Re : Land at Stakers Farm, Yapton – Y/71/20/RES

Further to the e-mail of the 15th September 2020 containing drainage queries we would like to provide additional information to address these.

Rev	Amendments	Drn	Chk	App	Date
Scale	@A3	Date	SEP 2020	Designed	AK
Drawn	AK	Checked	SW	Approved	SW
Job No	19-156	Drawing No	YAP-130-27	Rev	-

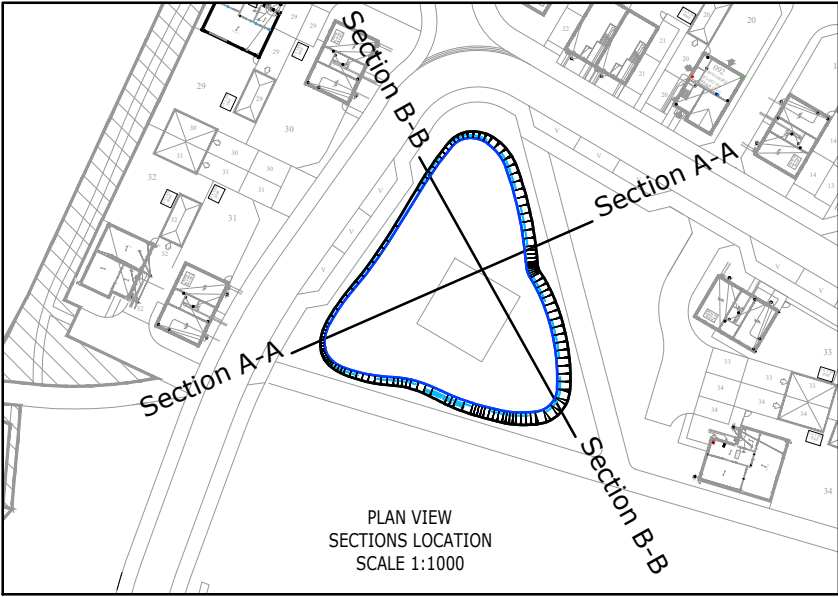
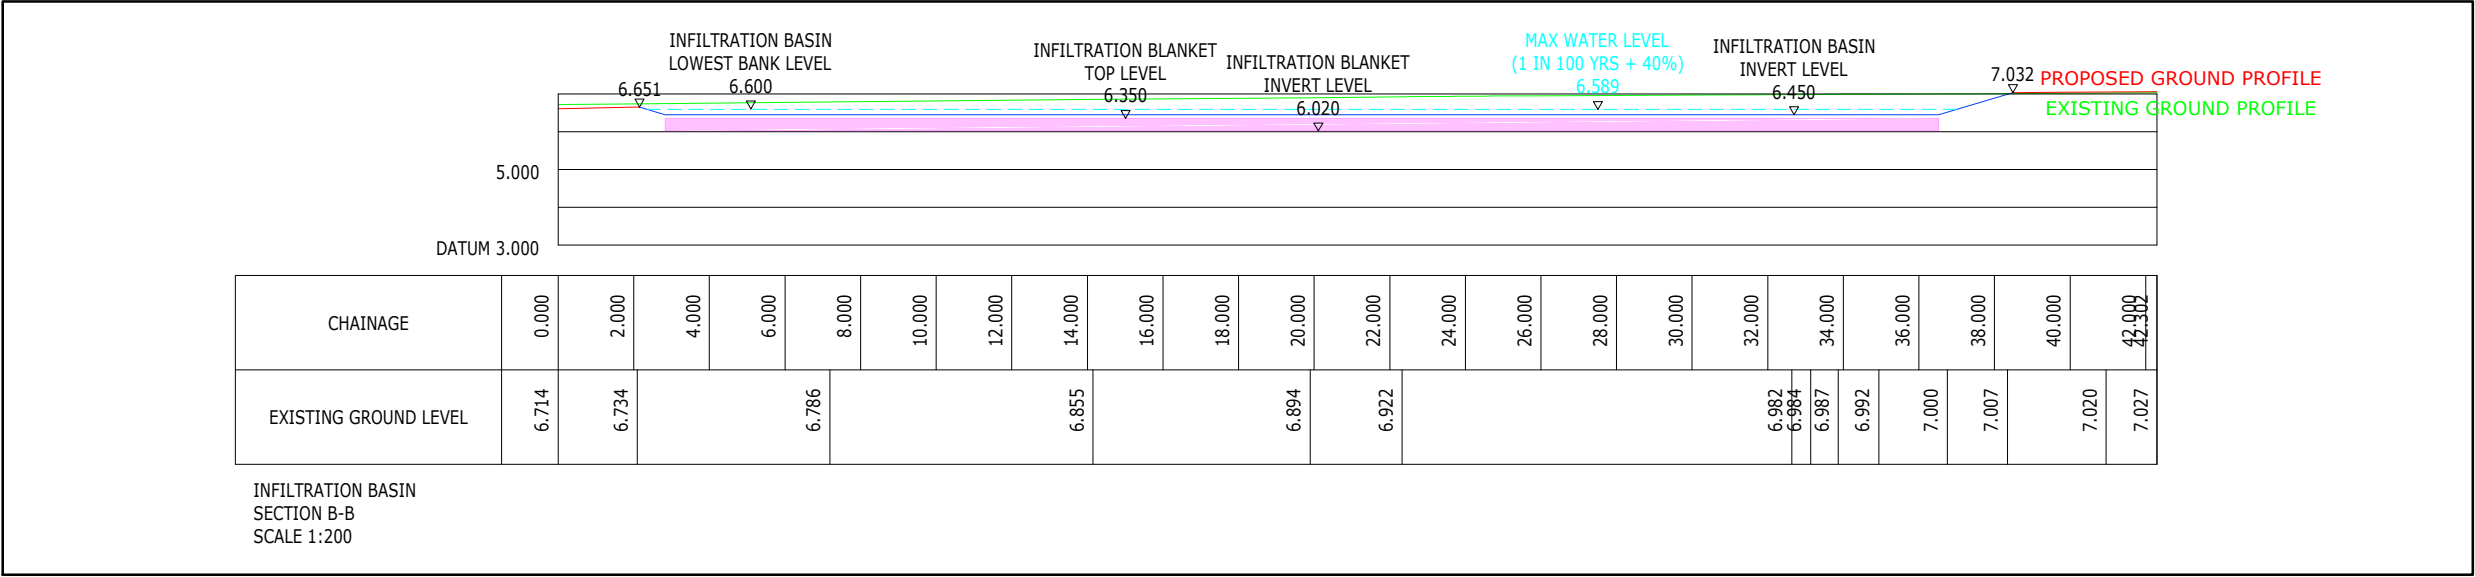
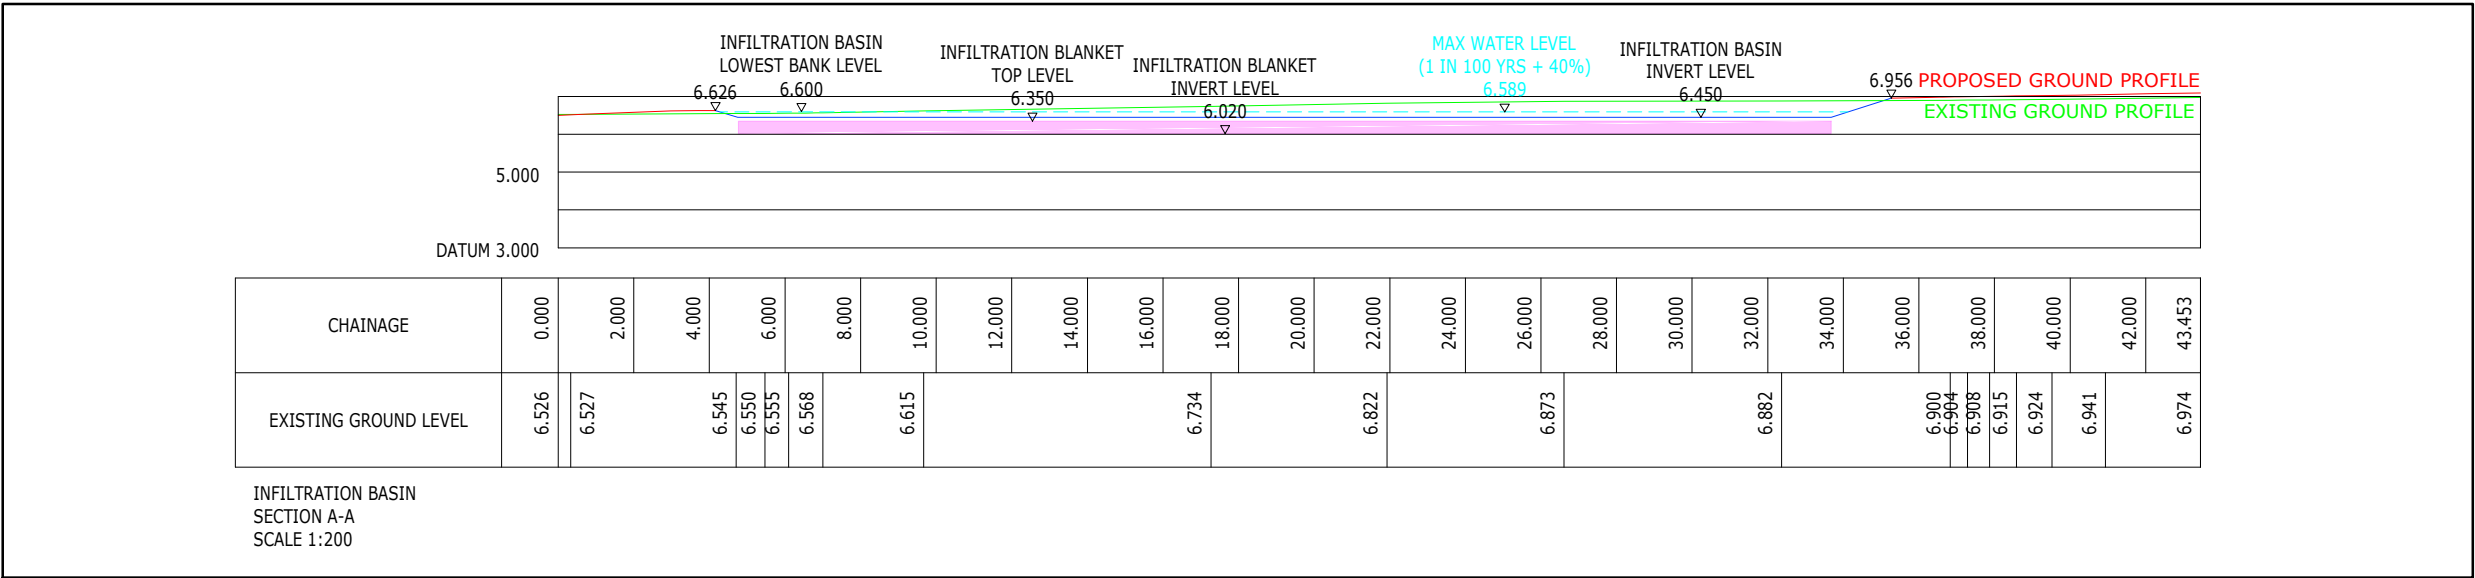
2. *"Please provide two perpendicular site specific cross sections of the proposed infiltration basin. These should show invert level..."* – Please refer to drawings YAP-130-27 and YAP-180-32A and its 'Gully grating within infiltration basin' detail.

Job Title		
LAND AT STAKERS FARM, YAPTON		
Drawing Title		
PERVIOUS SYSTEM NETWORK (38 UNITS)		
Client		
DANDARA LIMITED (SOUTHERN)		
Scale	Date	Designed
1:500@A1	SEP 20	AK
Drawn	Checked	Approved
AK	SW	SW
Job No	Drawing No	Rev
19-156	YAP-130-28	-

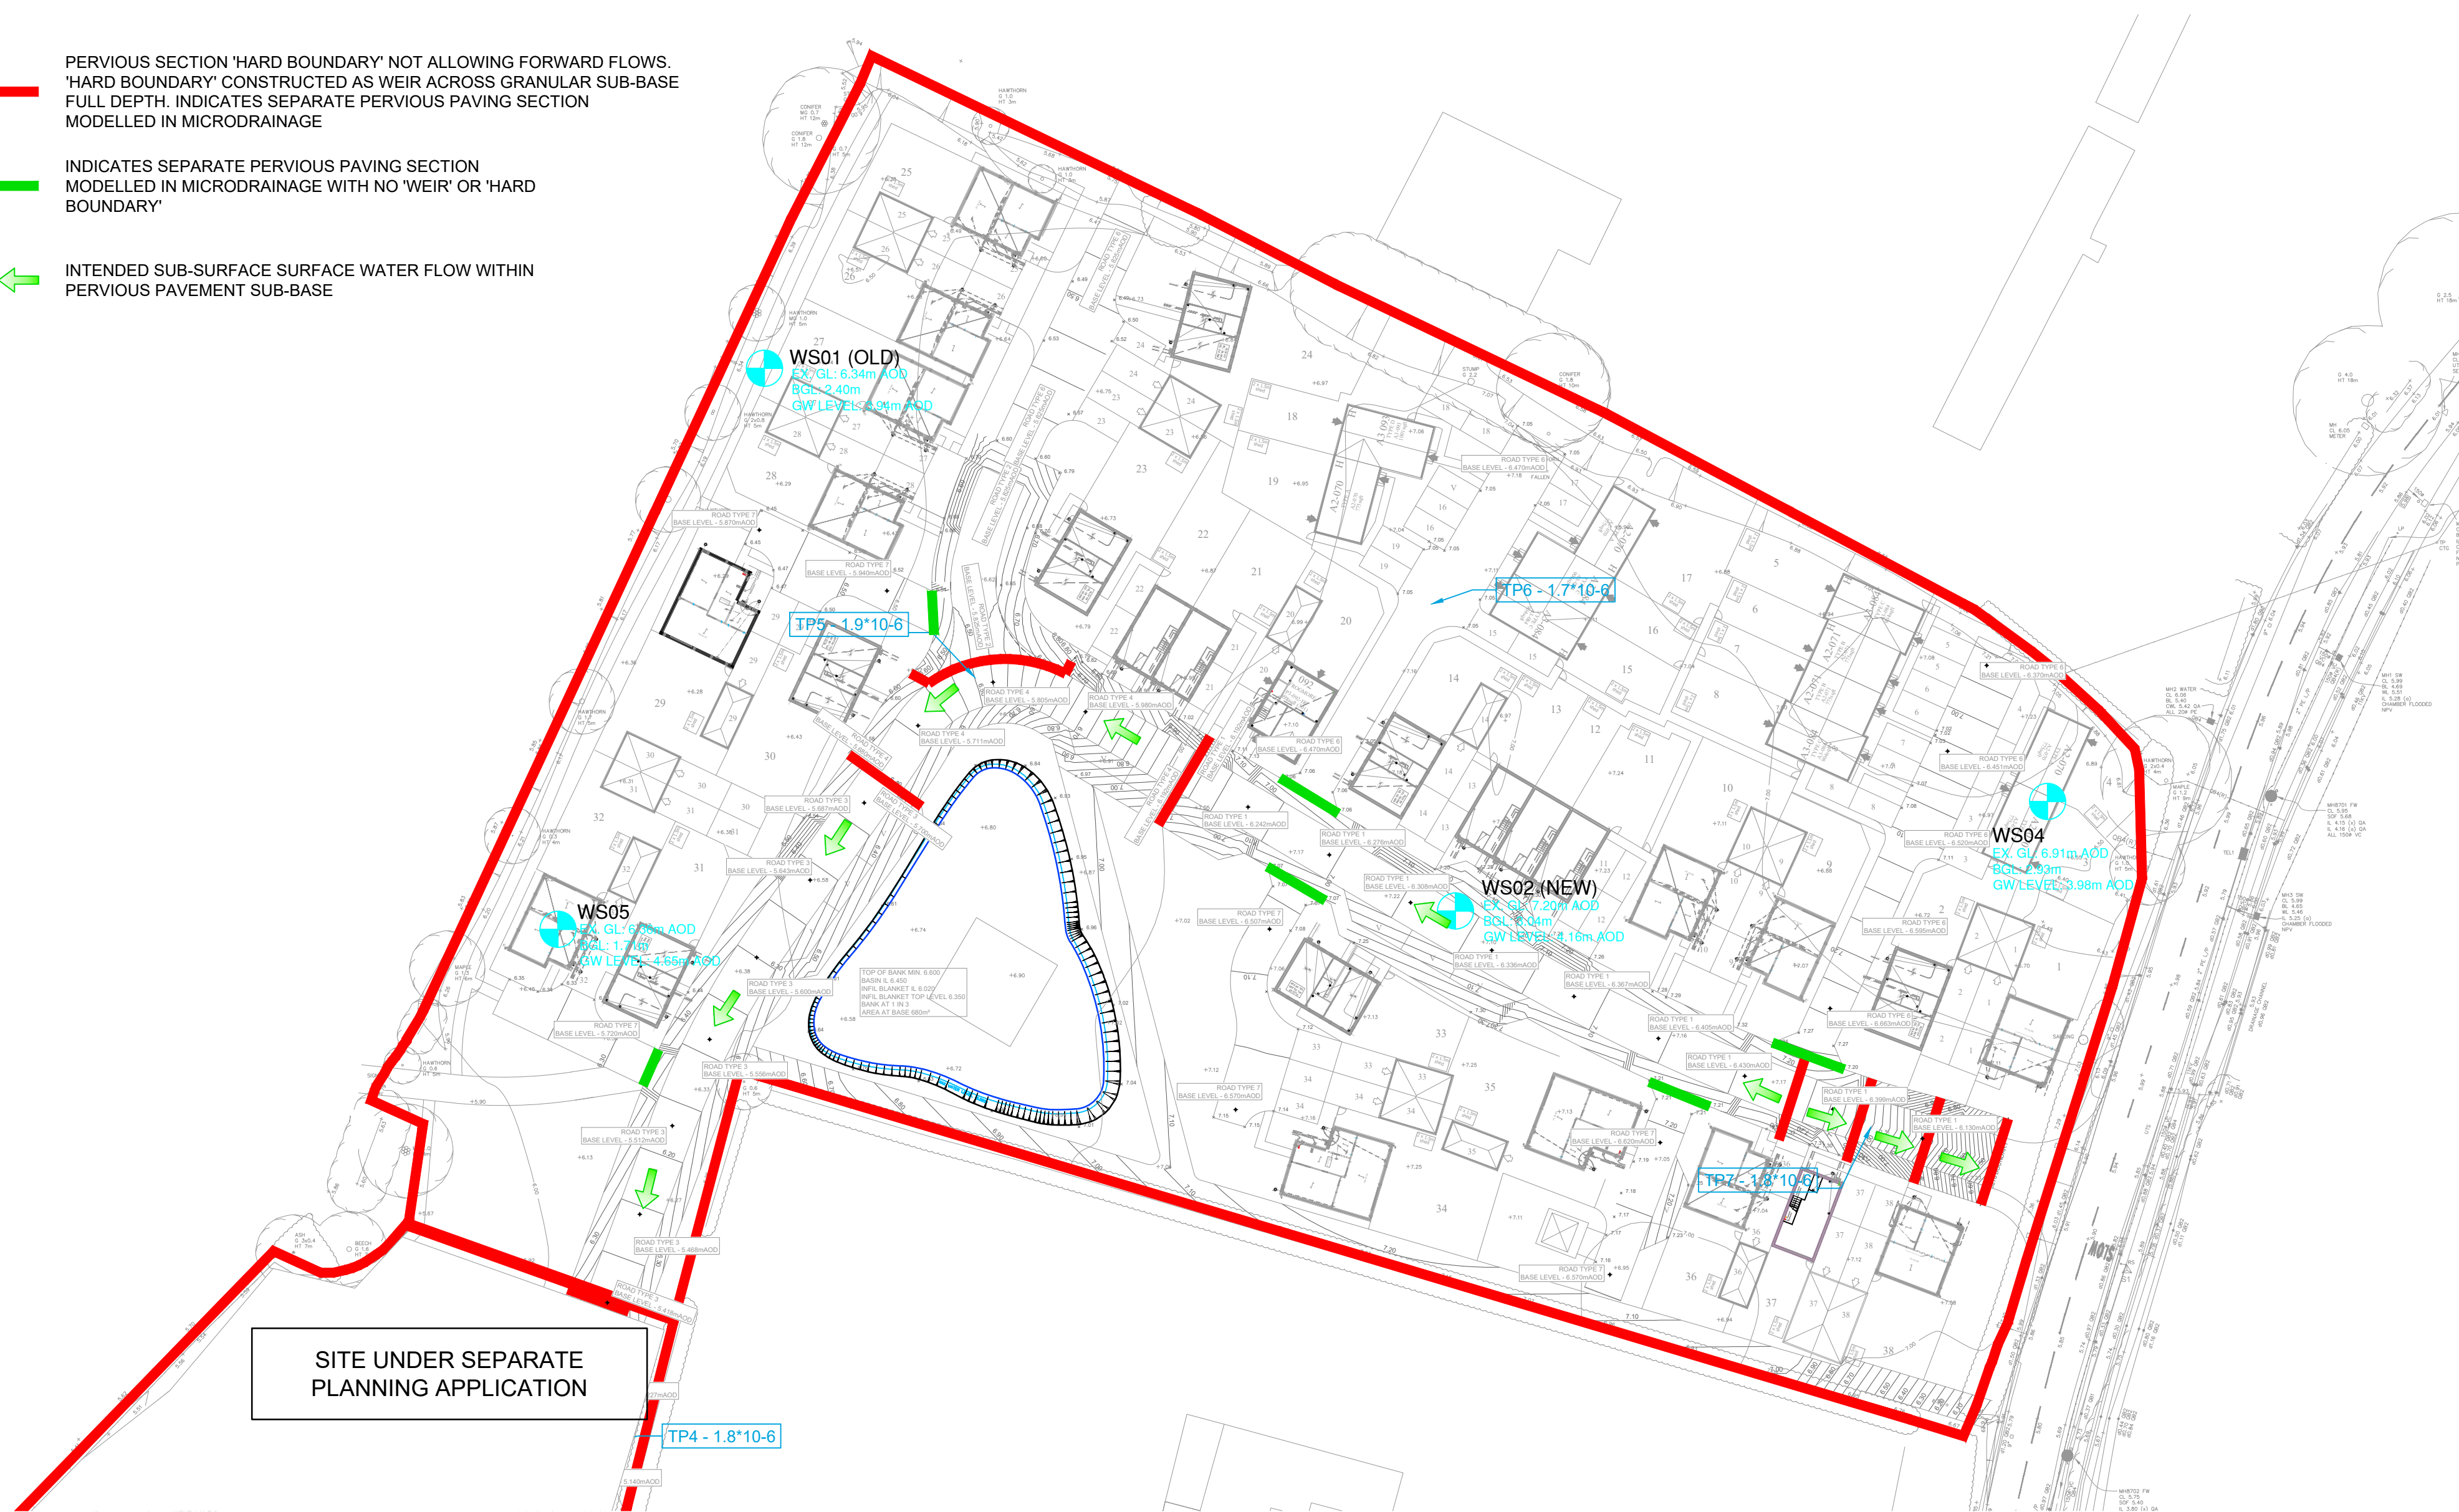
4. *"It is understood that the permeable paving areas will not have a flat sub-base, please provide spot levels..."* – Please refer to drawing YAP-130-28.

5. *"Construction detail drawings of check dams have been provided, please clearly indicate on plan..."* - Please refer to drawings YAP-130-20B and YAP-130-28.

Scale AS SHOWN	Date JUL 20	Designed CJL
Drawn CJL	Checked SW	Approved JHM
Job No 18-204	Drawing No YAP-180-32	Rev A

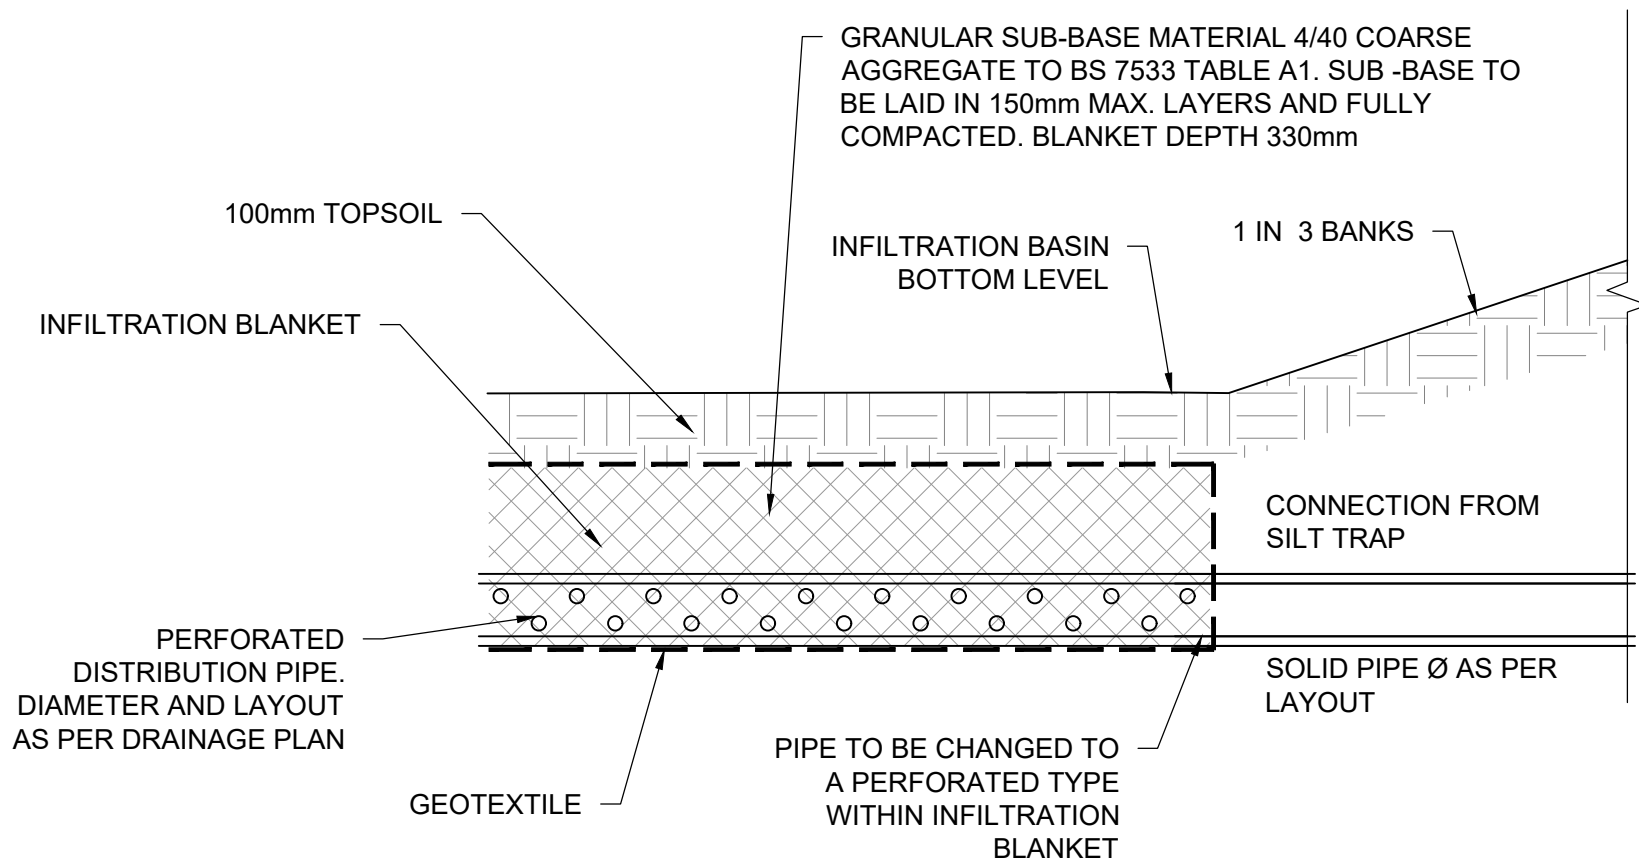
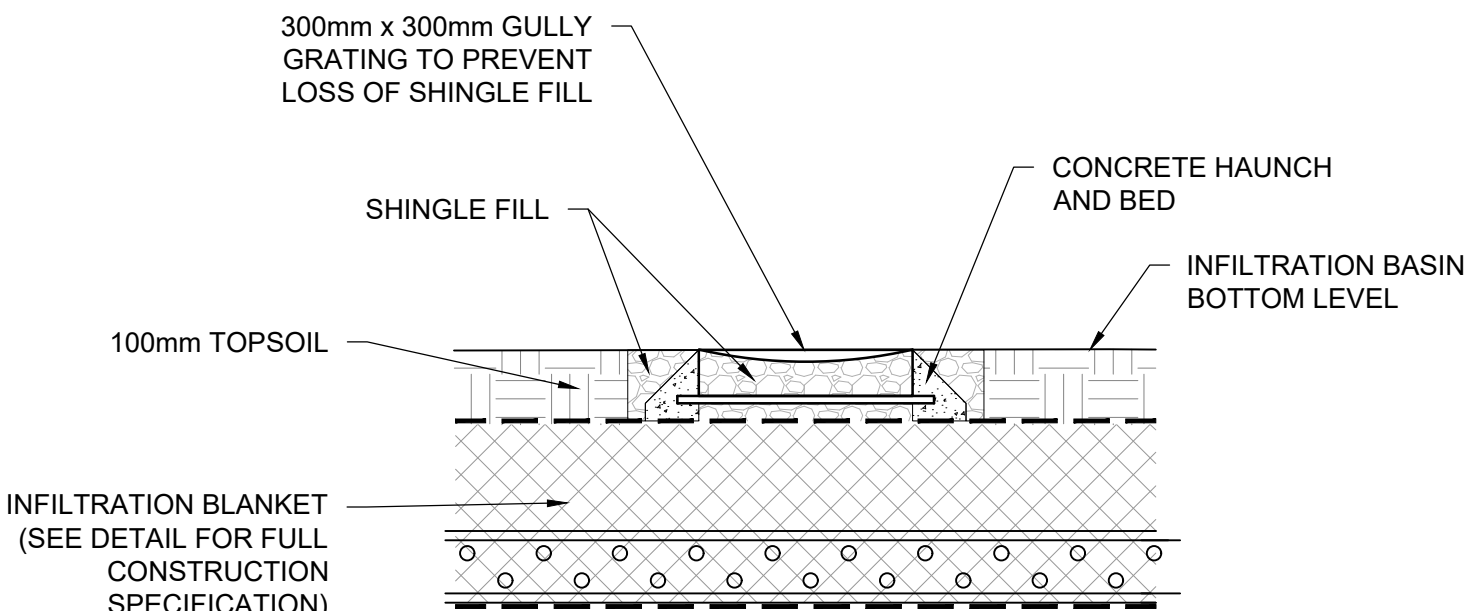
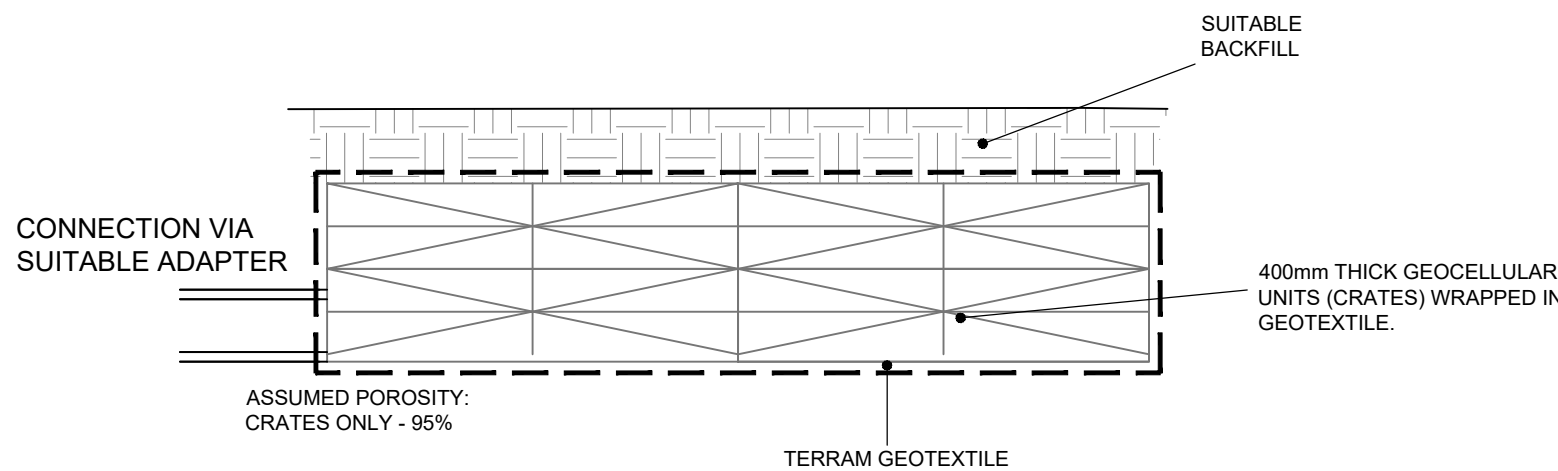
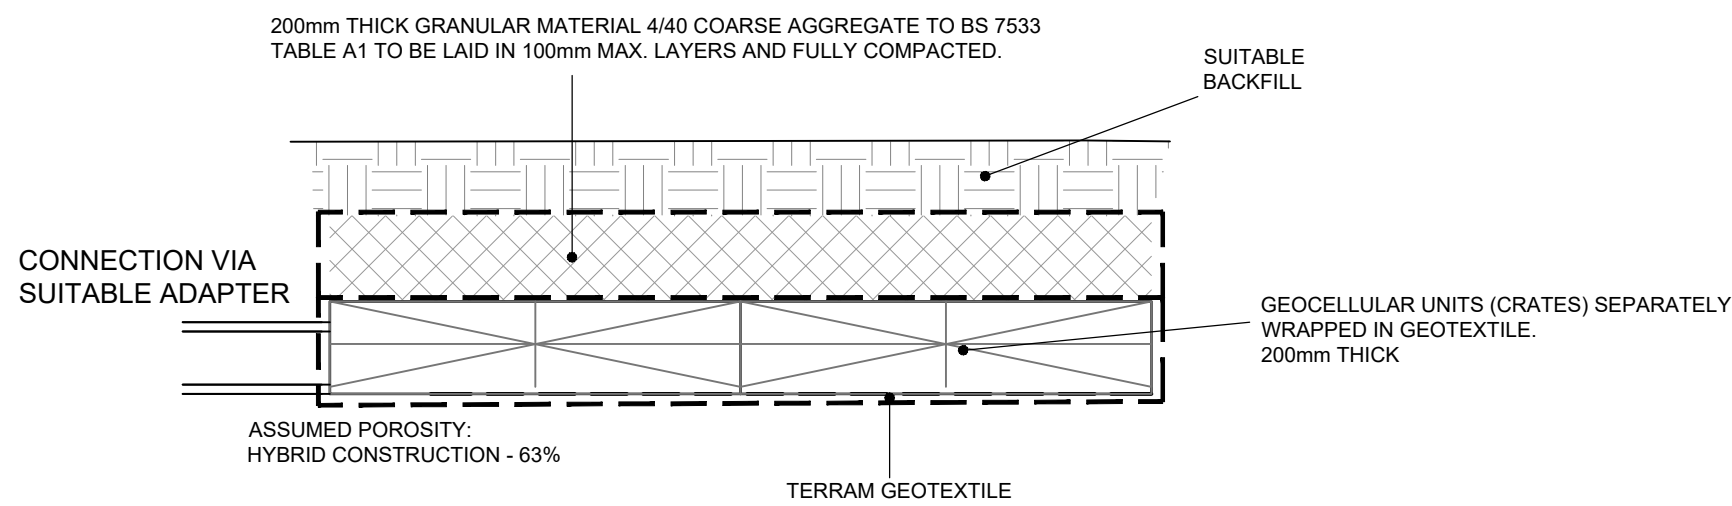
5. *"The construction detail drawing of the infiltration blankets needs to clearly show the layers of geotextile separating the geocellular units from the stone..."* - Please refer to drawing YAP-180-32A which states that geotextiles are to be used - as opposed to impermeable geomembranes. Please also refer to letter 'SEL 19-156 Stakers Farm Yapton' which is manufacturer's confirmation on suitability of 'Permavoid' geocellular units used in trafficked scenarios. Compaction method is stated on drawing YAP-180-35 for Permavoid units used underneath the road and. For different geocellular units (i.e. used in gardens) the exact product is not specified (as a minimum it must have 95% voids - as stated on drawing YAP-180-32A – and the overall plan and height dimensions of the feature must be met) as it will be a choice of a Client or contractor and in such instance manufacturer's installation guidelines must be followed.
